Application no: H08-0312-11

Description: Proposed car hand wash and valeting service on part of existing car lot site

Location: 1 Spalding Road
Gosberton
Spalding
Lincs
PE11 4NP
PE11 4NP

Amendment: Amended plan showing drainage channels and screen
wall (dwg. no. 1SPL-01-01A)

Client MR A ALI		Project PROPOSED HAND WASH & VALETING FACILITY AT 1 SPALDING ROAD GOSBERTON, SPALDING PE11 4NP	
Drawing PROPOSED PLAN			
Date MAR 11	Scale 1:100 @ A1	Drawing No. 1SPL-01-01	Revision A

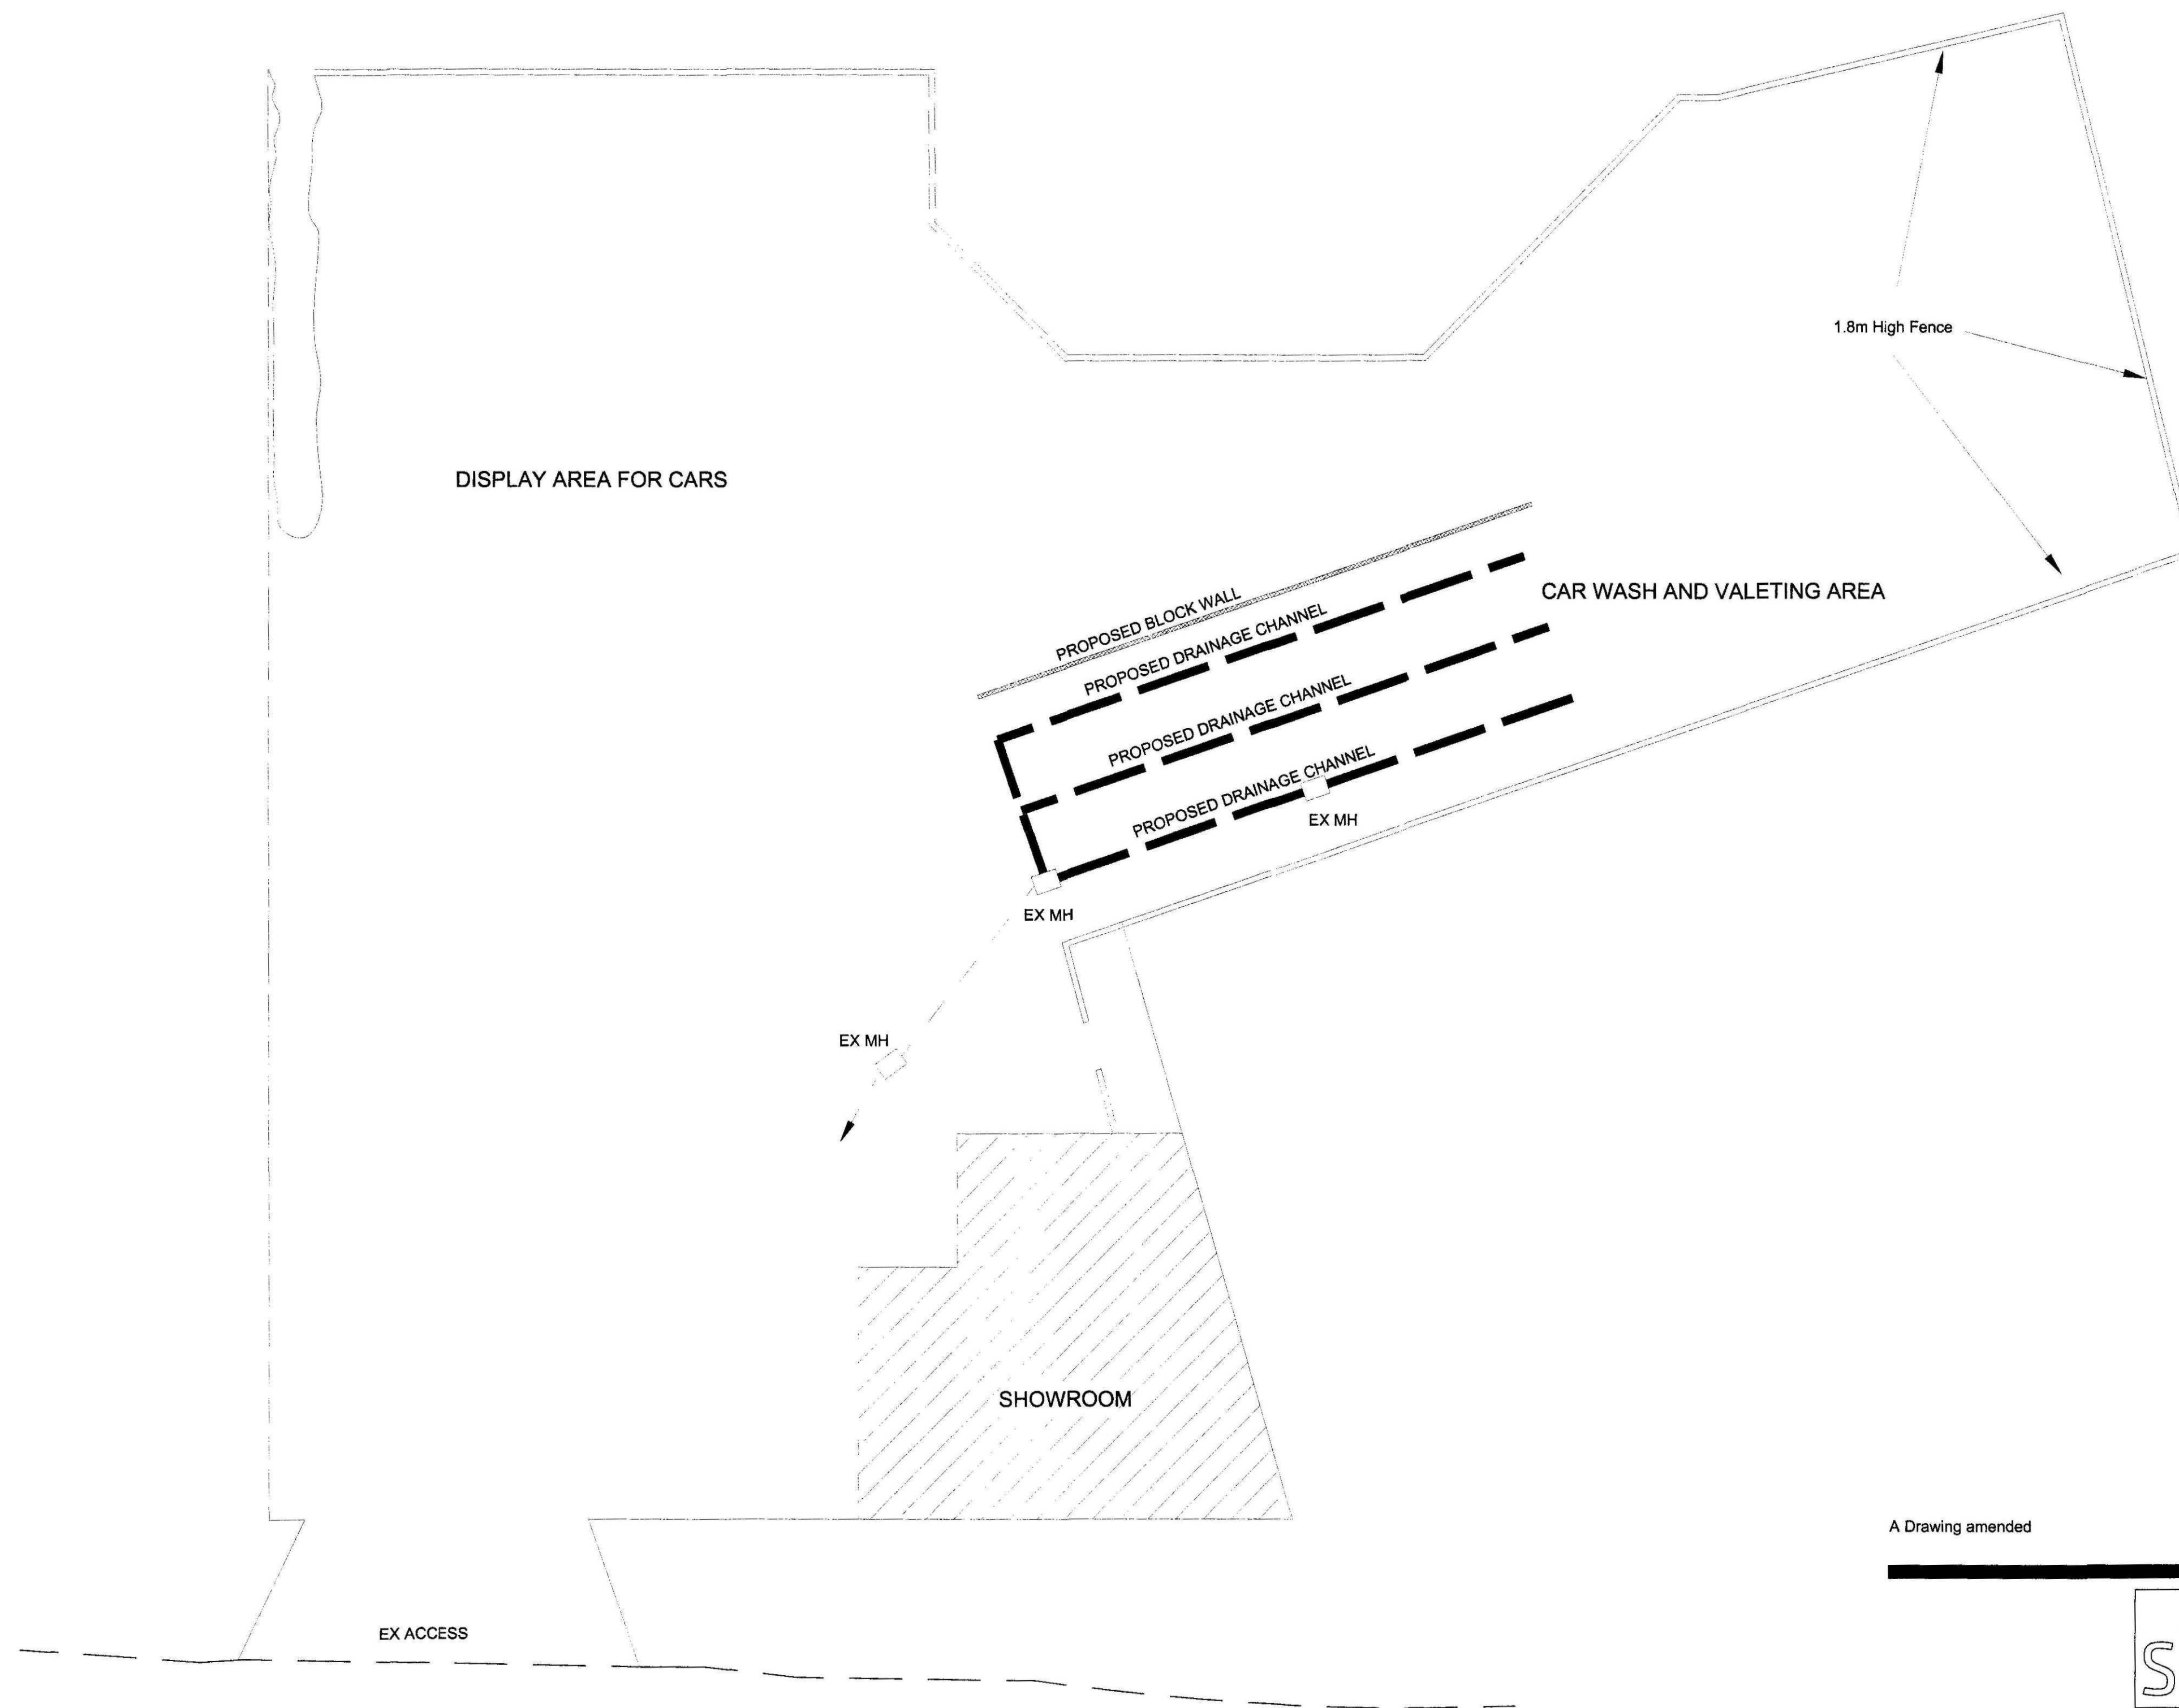
> Having visited the site yesterday I would be grateful if you could
 > clarify what the newly constructed breezeblock and timber structure is
 > for, and whether your client intends to add a roof or enclosed sides to
 > this?

> Also, the drawings submitted as part of the application do not match the
 > drainage layout that has been constructed on site. Please provide
 > accurate drawings that show precisely what has been constructed/is
 > proposed.

Amended plan - drainage channels and screen wall

With reference to your below e-mail regarding the above site please find attached revised drawing. The purpose of the block wall is to form a route to direct/ segregate the incoming and outgoing traffic who wish to use the washing/valeting facilities, it also act as a barrier to prevent the runoff from the pressure washers running towards the trees. The client has confirmed that the structure will not have a roof or will not be enclosed in any way it will be a free standing wall.
